<b>Application Ref:</b>	3/2025/0965			 Ribble Valley Borough Council <a href="http://www.ribblevalley.gov.uk">www.ribblevalley.gov.uk</a>				
<b>Date Inspected:</b>	07/01/2026	<b>Site Notice:</b>	07/01/2026					
<b>Officer:</b>	MC							
<b>DELEGATED ITEM FILE REPORT:</b>					<b>REFUSAL</b>

<b>Development Description:</b>	Proposed extension of agricultural building to form machinery storage and regularisation of existing hard standing (part retrospective).
<b>Site Address/Location:</b>	Land off Longridge Road Hurst Green BB7 9QP

Proposed elevation
 Land off Longridge Rd
 Hust Green
 BB7 9AP

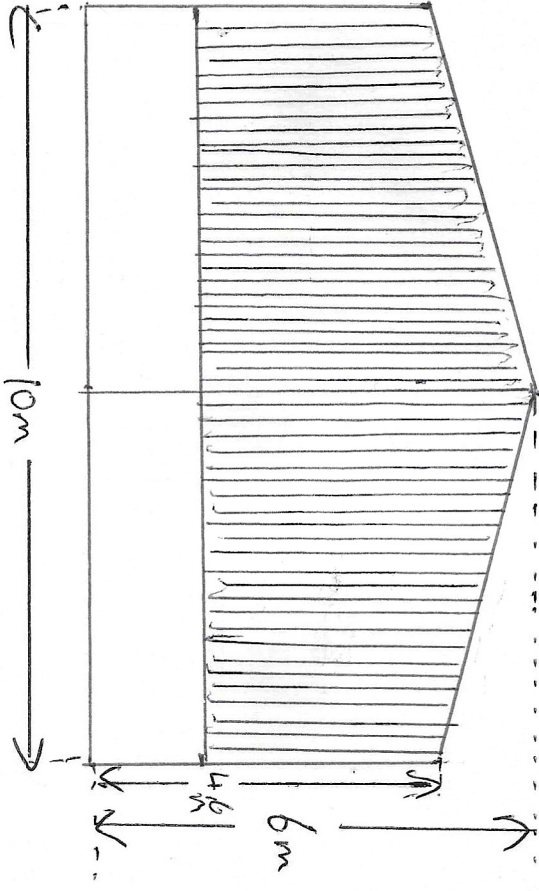
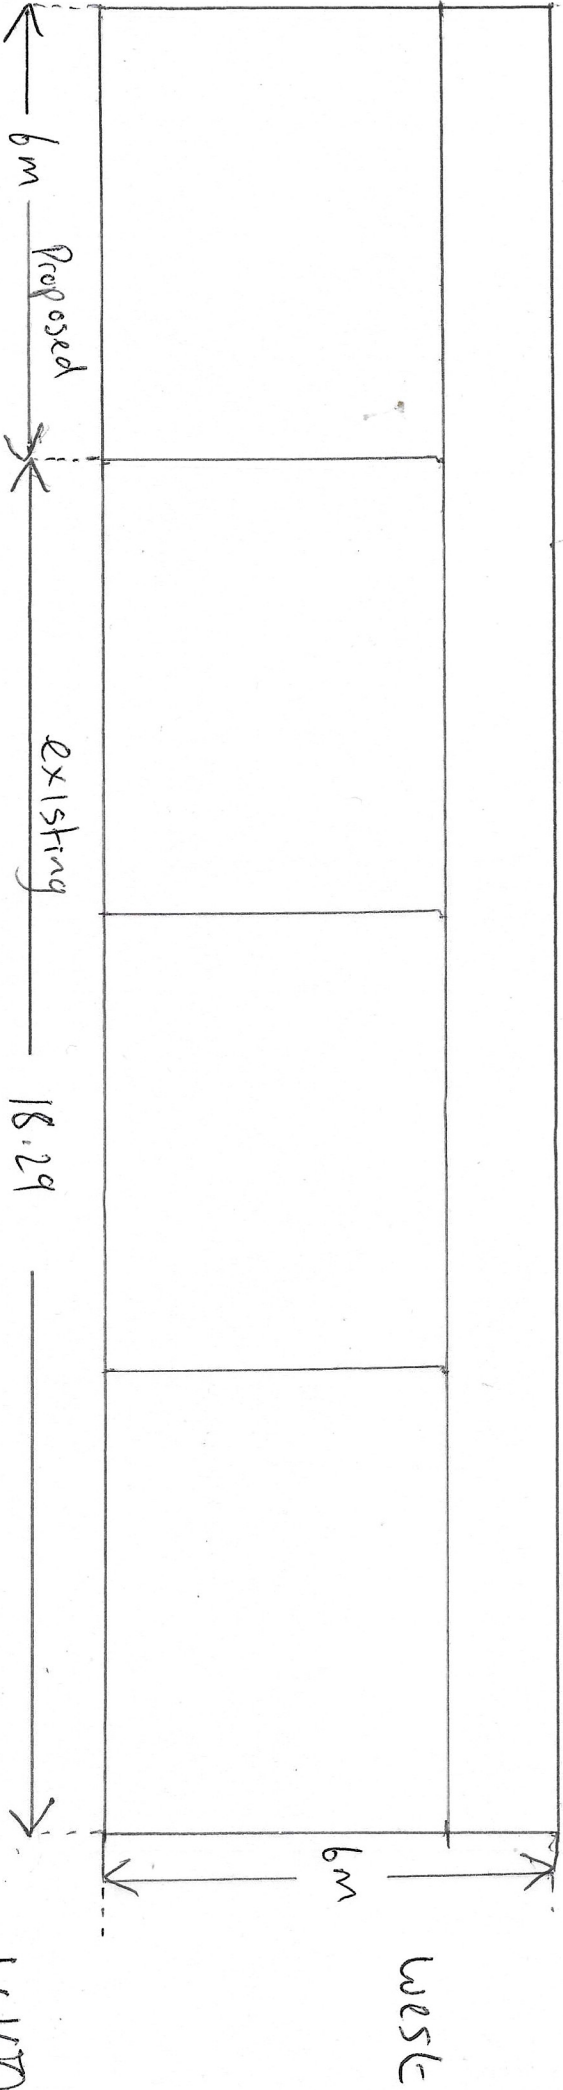
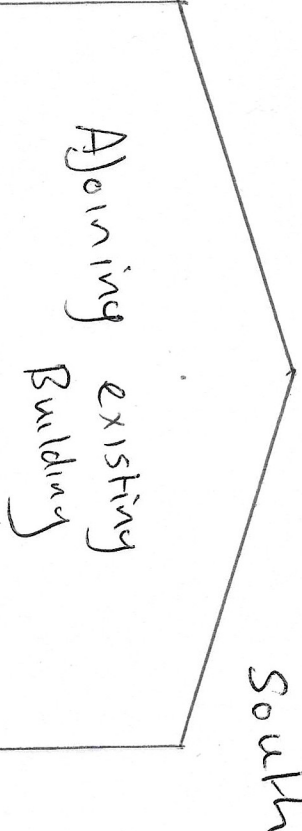
It is considered that a further extension to the building would add bulk and mass to an existing moderately sized agricultural building within the Forest of Bowland National Landscape. The siting of the extension would result in a building of such a size that is considered to result in harm to the special qualities of the Forest of Bowland National Landscape by way of loss of openness and additional bulk and massing. As previously stated, the Council have only recently approved an additional extension to the building and any further extensions would visually detract from the rural landscape which is visible from the Public Bridleway and long-distance views from the Public Footpath which runs to the south of Adamson House.

The proposed extension by reason of its size, scale and siting would result in the loss of openness and additional bulk and mass within the site. In addition, the hardstanding would result in a harmful urbanising impact and erosion of rural landscape, both of which would fail to protect, conserve or enhance the landscape and character of the Forest of Bowland National Landscape, contrary to Key Statement EN2 and Policies DMG1 and DMG2 of the Ribble Valley Core Strategy.
